**Our ref:** HA/2025/126664/01  
**Your ref:** LU/57/25/PD

**PRIOR NOTIFICATION UNDER SCHEDULE 2, PART 3, CLASS MA FOR THE  
CHANGE OF USE OF PART OF BUILDING ON GROUND FLOOR FROM  
RESTAURANT (CLASS E) TO DWELLING HOUSE (CLASS C3).**

**51 PIER ROAD, LITTLEHAMPTON, BN17 5LP.**

Ground Floor Plan - Proposed

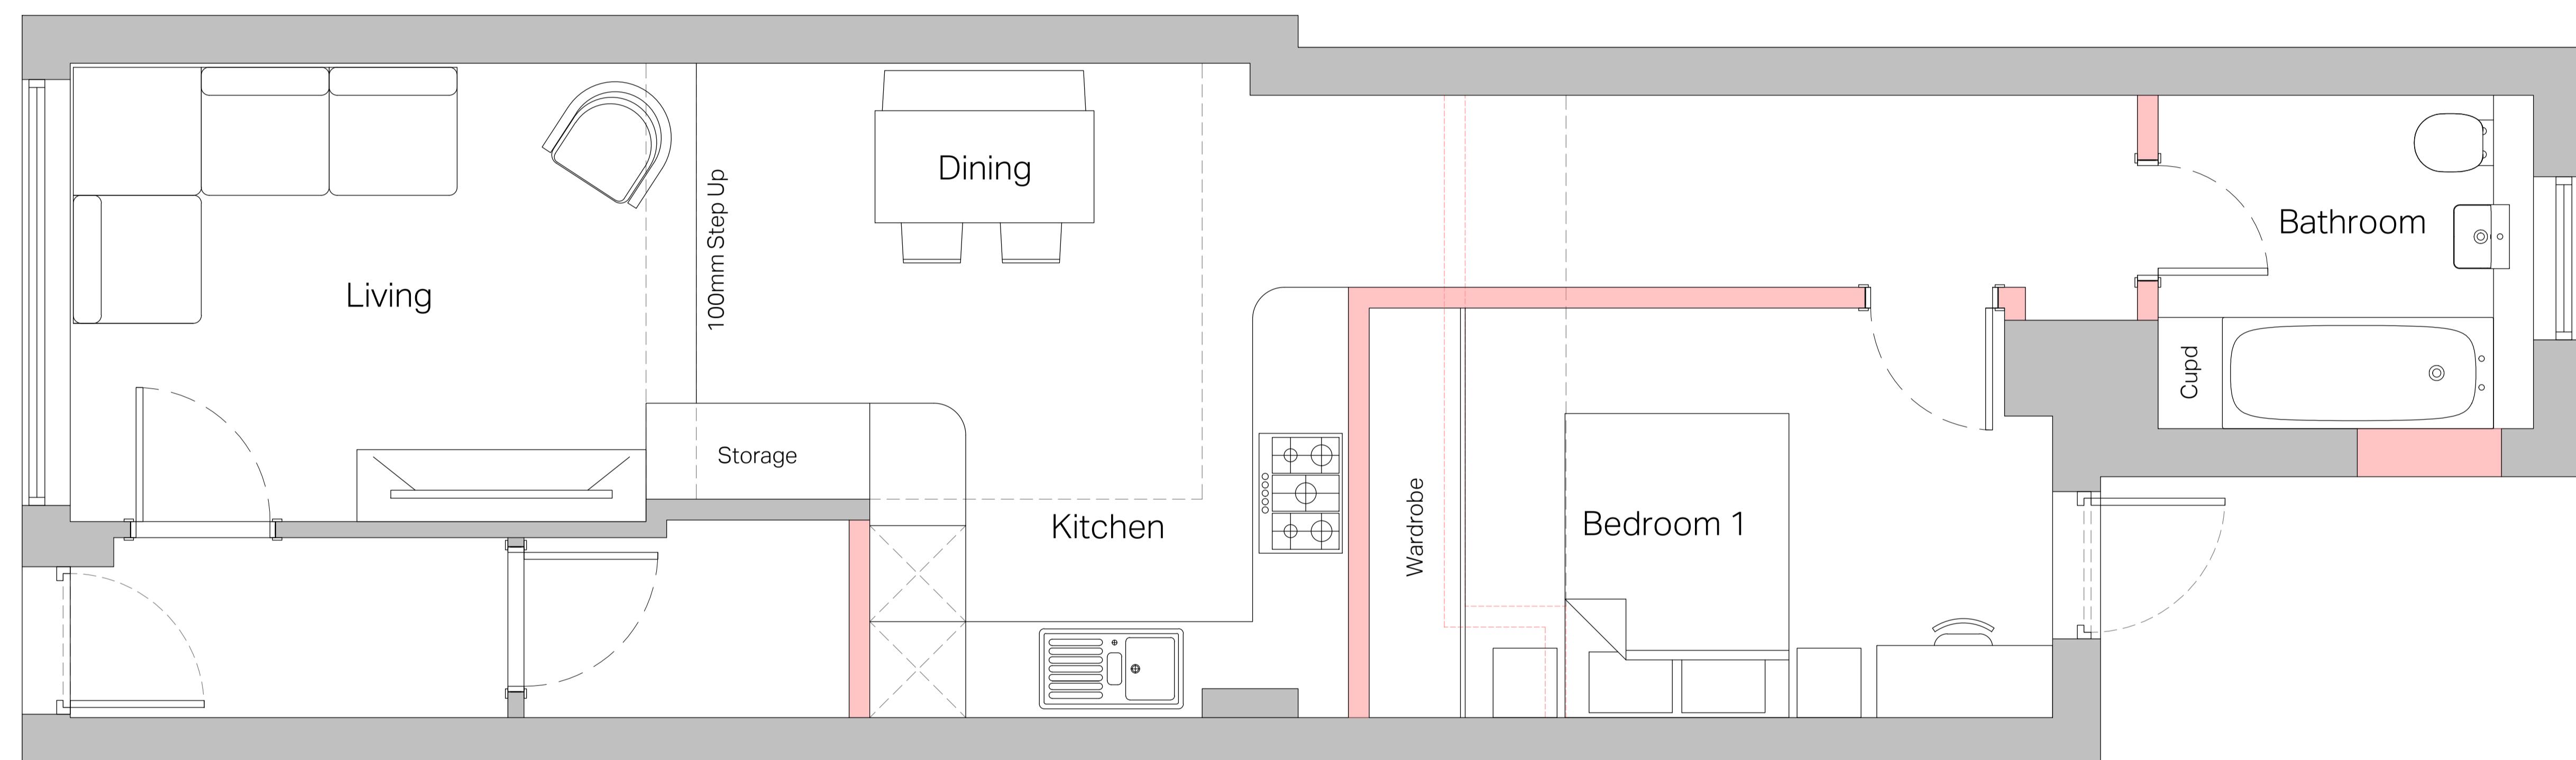
The application does not demonstrate that occupants can remain safe for the lifetime of the development. We would request that a revised application considers the undefended modelling scenario to demonstrate how the proposed development – specifically, the ground floor sleeping accommodation – will be kept safe from the identified flood hazards.

To overcome our objection, the applicant should submit evidence to demonstrate that the proposal will not pose a risk to life and/or property as highlighted above. If this cannot be achieved, we are likely to maintain our objection.
